Application Ref:	3/2025/0377				Ribble Valley Borough Council www.ribblevalley.gov.uk
Date Inspected:	20/6/25	Site Notice:	20/6/25		
Officer:	BT				
DELEGATED ITEM FILE REPORT:				Decision	REFUSAL

Development Description:	Prior approval for the proposed change of use of a former agricultural building to one dwellinghouse under Schedule 2, Part 3 Class Q of the GPDO.
Site Address/Location:	Fields Farm, Mearley, Pendleton, BB7 1PU.

<b>project</b> fields farm	<b>project number</b> 25.07	<b>drawing number</b> <b>PL.01</b>
<b>name</b> proposed - site plan		
<b>scale</b> 1 to 100 @ A1	<b>date</b> may 2025	<b>status</b> planning
		<b>revision</b> A

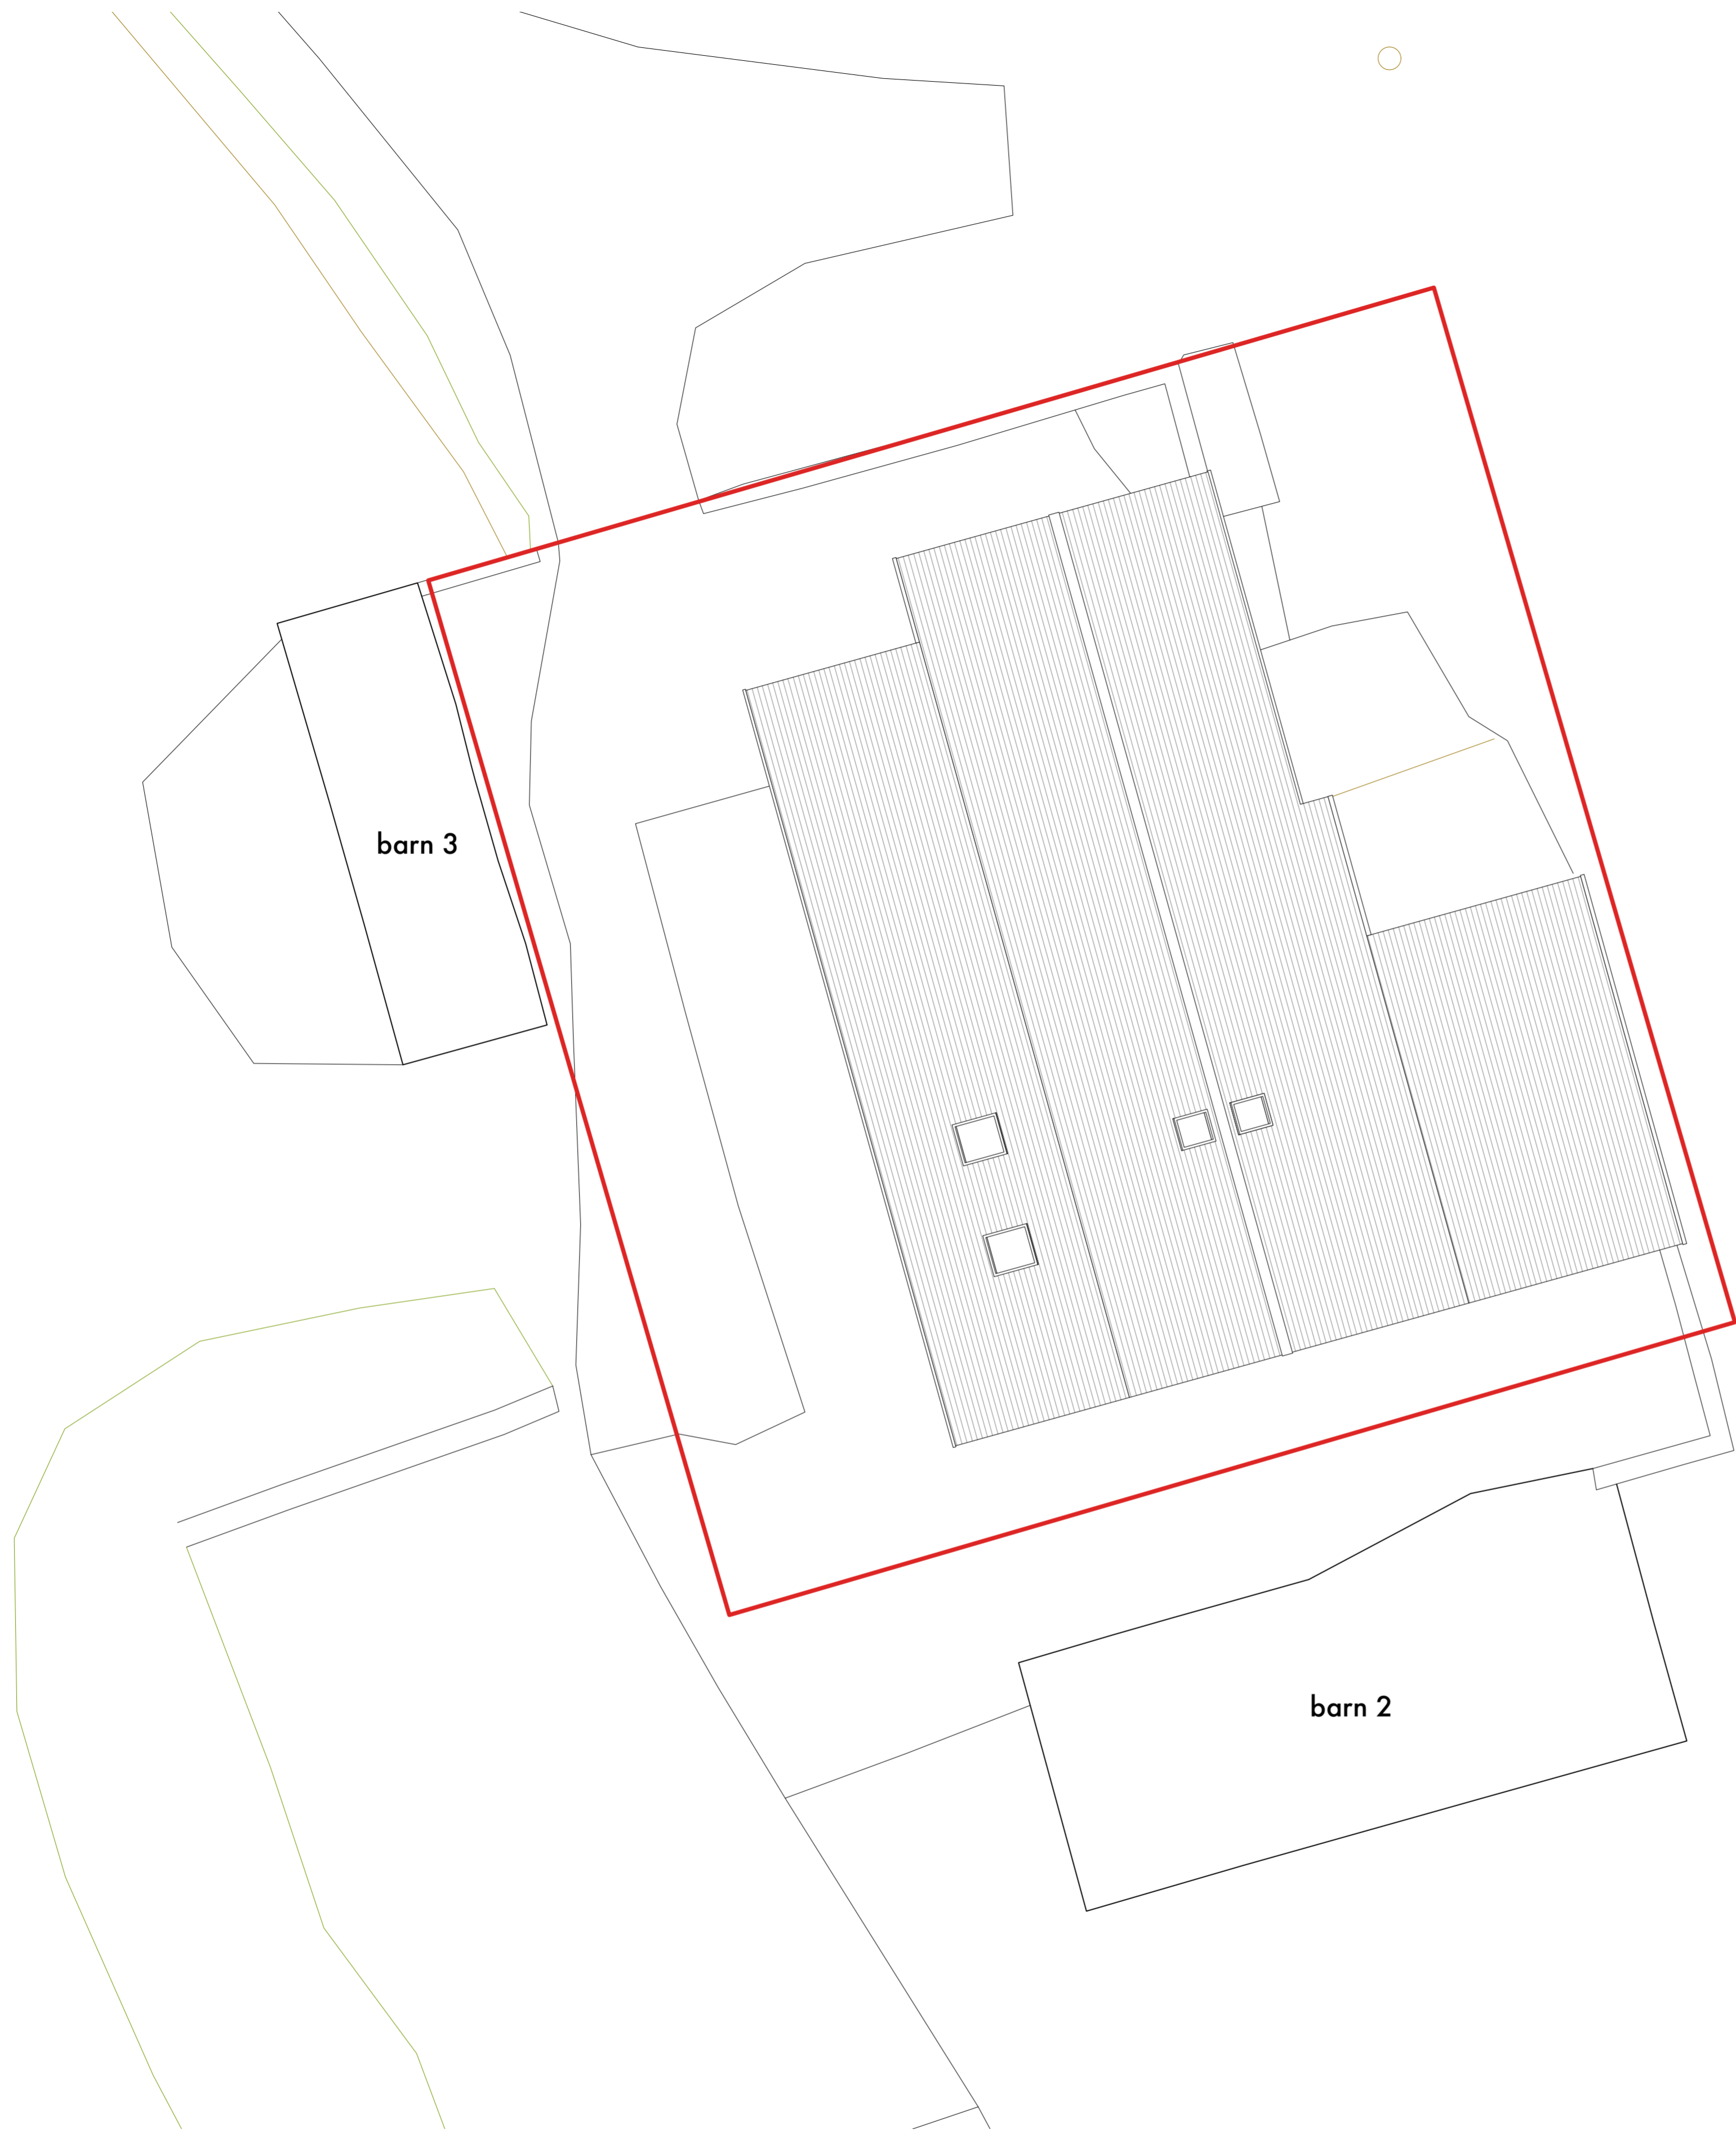
The proposed site plan submitted with the application indicates that the proposed dwelling would comprise a domestic curtilage area. The cumulative area of land occupied by the proposed domestic curtilage area would amount to 281 square metres which would not exceed the ground floor area covered by the building to be converted to residential use. The proposed development is therefore considered to be acceptable in relation to this particular consideration.

project	project number	drawing number
fields farm	25.07	PL.0
name	location plan	
scale	date	status
1:1250 @ A1	may 2025	planning
		revision
		C

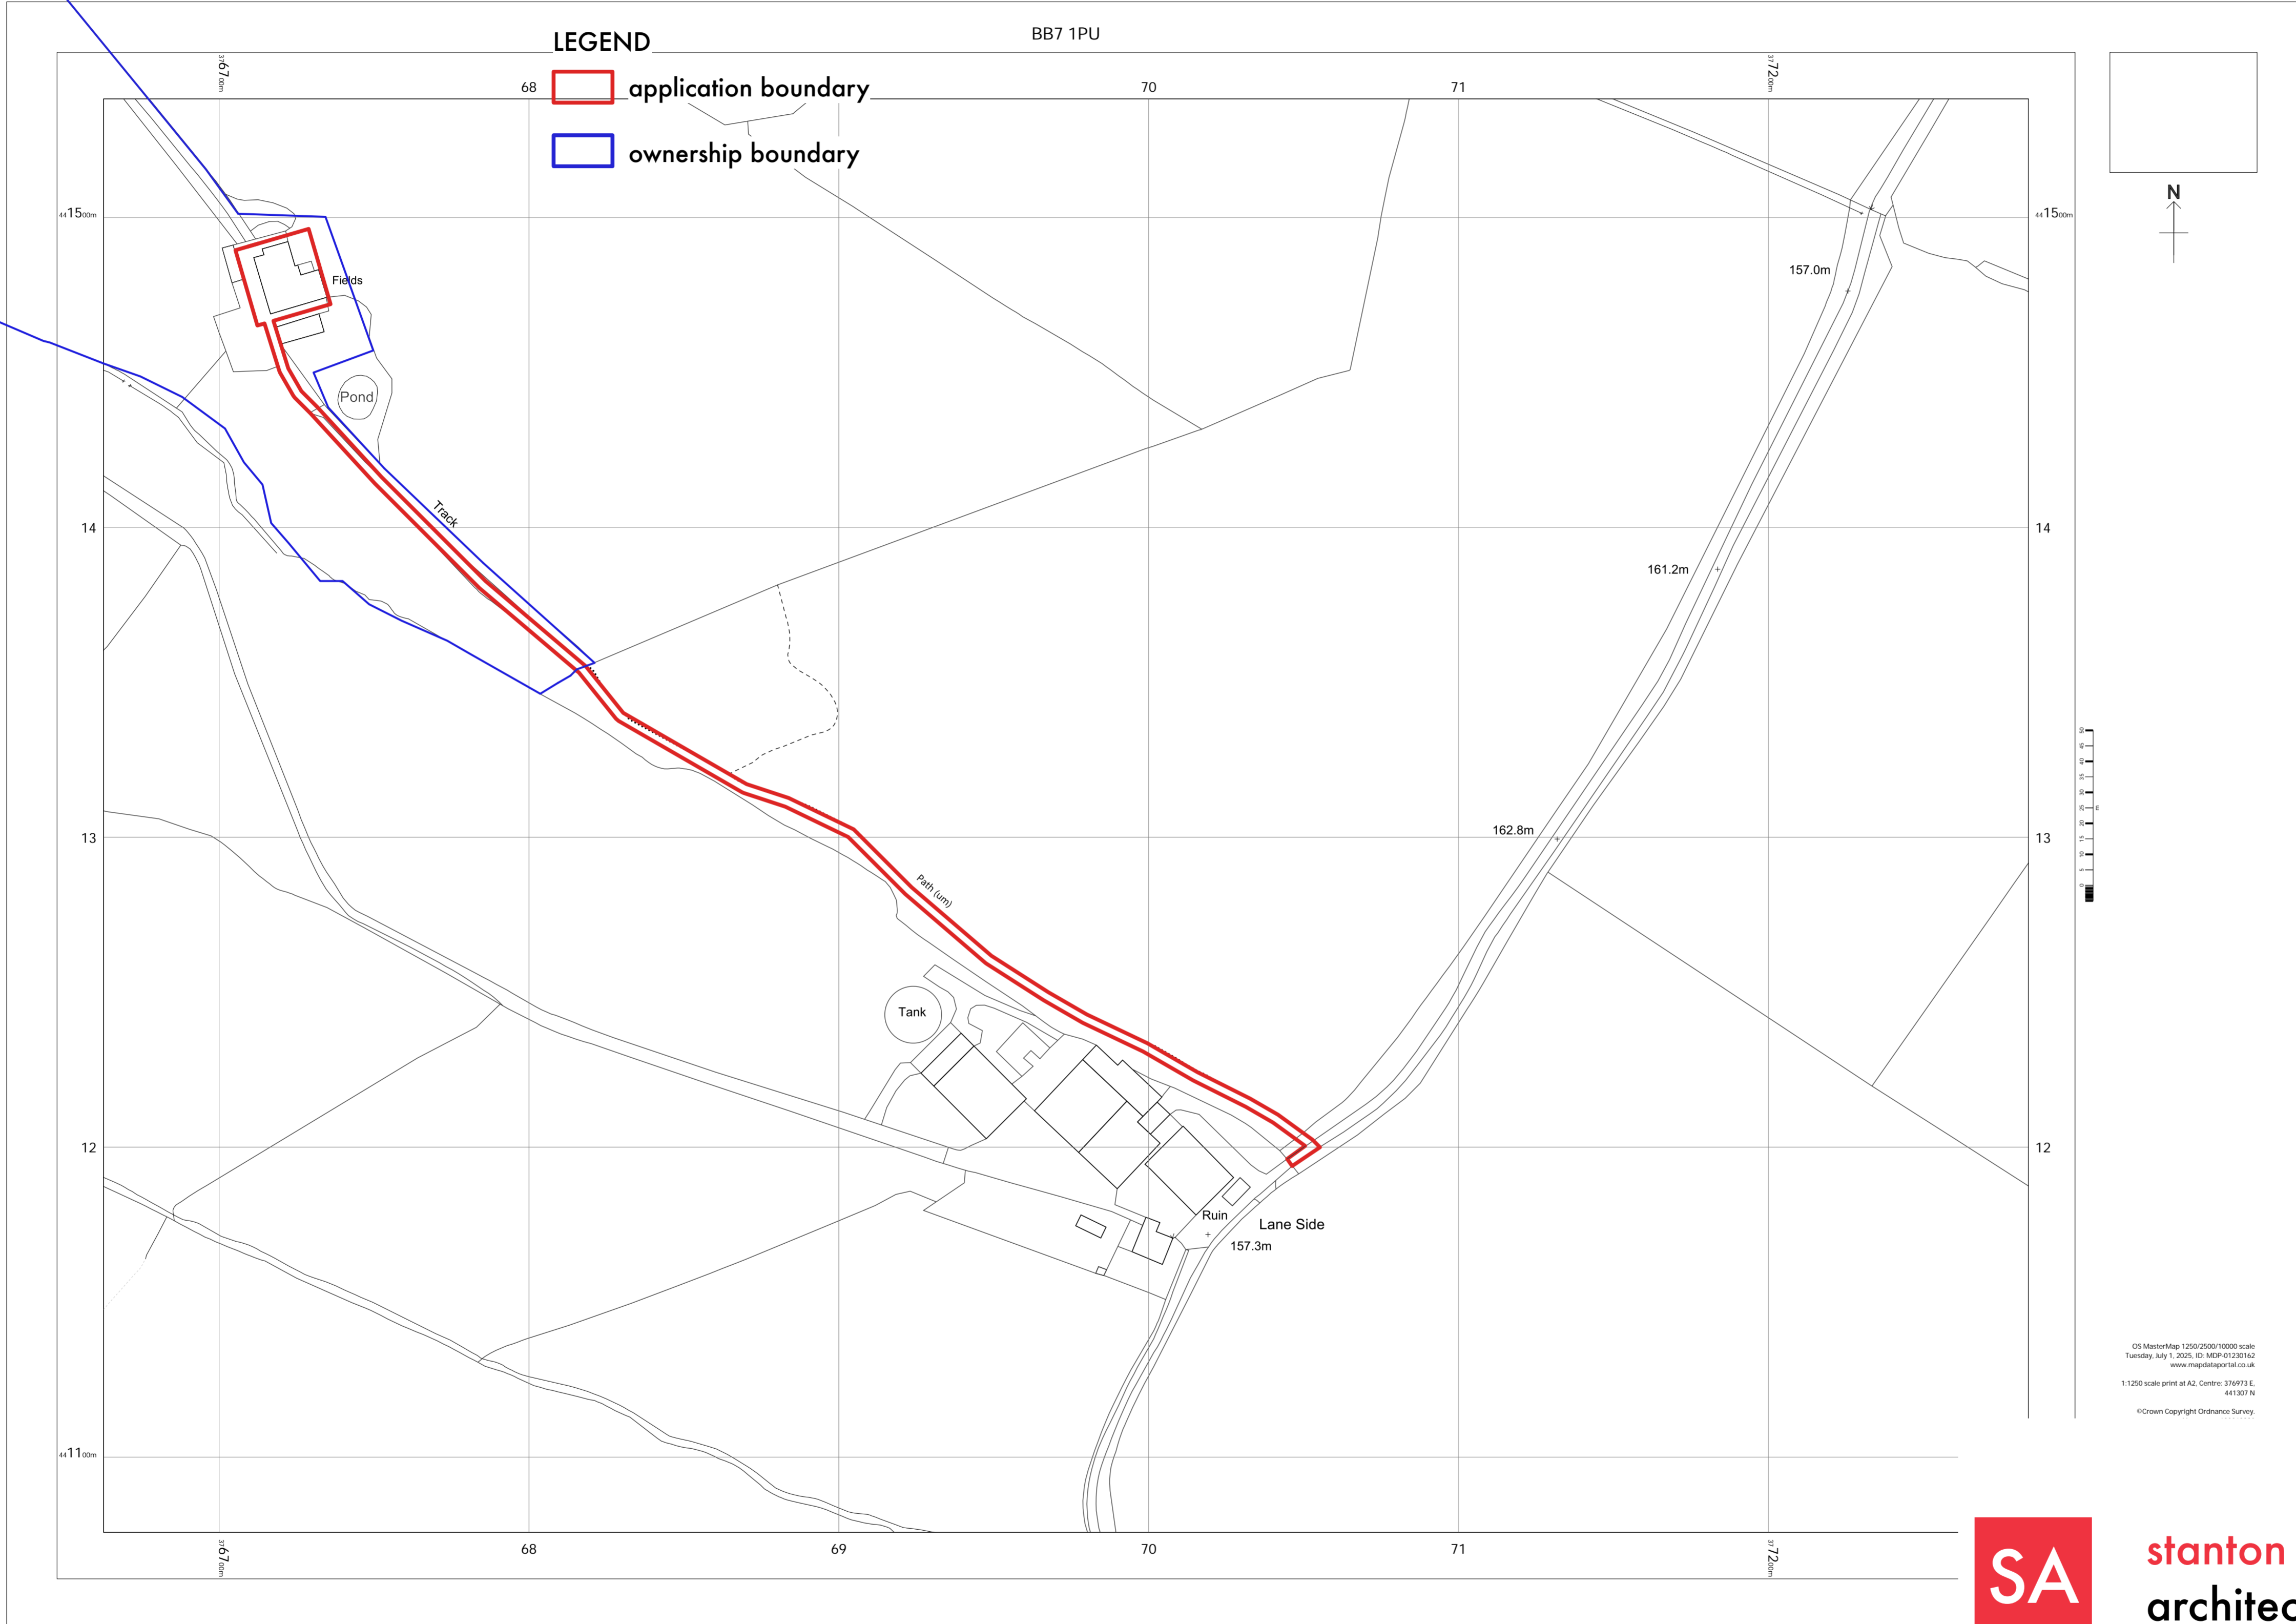
The proposed development has been subject to review from Lancashire County Council Highways who in their initial response recommended for refusal of the proposed development on the basis of the development originally seeking to introduce a new residential access to the site from the A59 highway which was not supported for reasons of highway safety. In light of these concerns the LHA advised for the use of Public Rights Of Way BW0324001 and FP0324004 from Clitheroe Road as an alternative means of access to the application site. An amended Location Plan has since been provided in support of the proposal which now seeks to utilise Public Rights Of Way BW0324001 and FP0324004 as a means of access to the proposed development. This arrangement has been subject to review from LCC Highways who have raised no issues with the alternative means of access proposed, subject to the applicant securing a right of access over the Rights Of Way which has subsequently been agreed with the relevant parties as confirmed by the applicant.

In this instance, approximately two thirds of the section of Public Right Of Way FP0324004 to the South-east of the application site comprises an unsurfaced grass footpath therefore additional works in the form of excavation and new surface treatments would be required to the Right Of Way in order for it to be utilised as the site's vehicular access as referenced in the latest response from the LHA. Notwithstanding this, the North-western end of the unsurfaced section of the Right Of Way lies approximately 150 metres away from the application site outside of the barn building's curtilage. Class Q of the GPDO is quite specific in the permitted development rights that it provides in as much that the legislation allows for the change of use of a building and any land within its curtilage from a use as an agricultural building to a use falling within Class C3 (dwellinghouses). In addition, it allows for building operations reasonably necessary to convert the building subject to conversion however the legislation does not allow for additional works beyond the scope of the application building or land within its curtilage in order to facilitate development (this is confirmed within recent appeal decisions Ref: APP/D0121/W/19/3240553 and APP/L3245/X/20/3256290).

In light of the above, the works of improvement required to the Right Of Way to facilitate access to the proposed development could not be satisfactorily or reasonably secured through the prior approval process in this instance. As such, prior approval is therefore required and refused in respect of this matter.
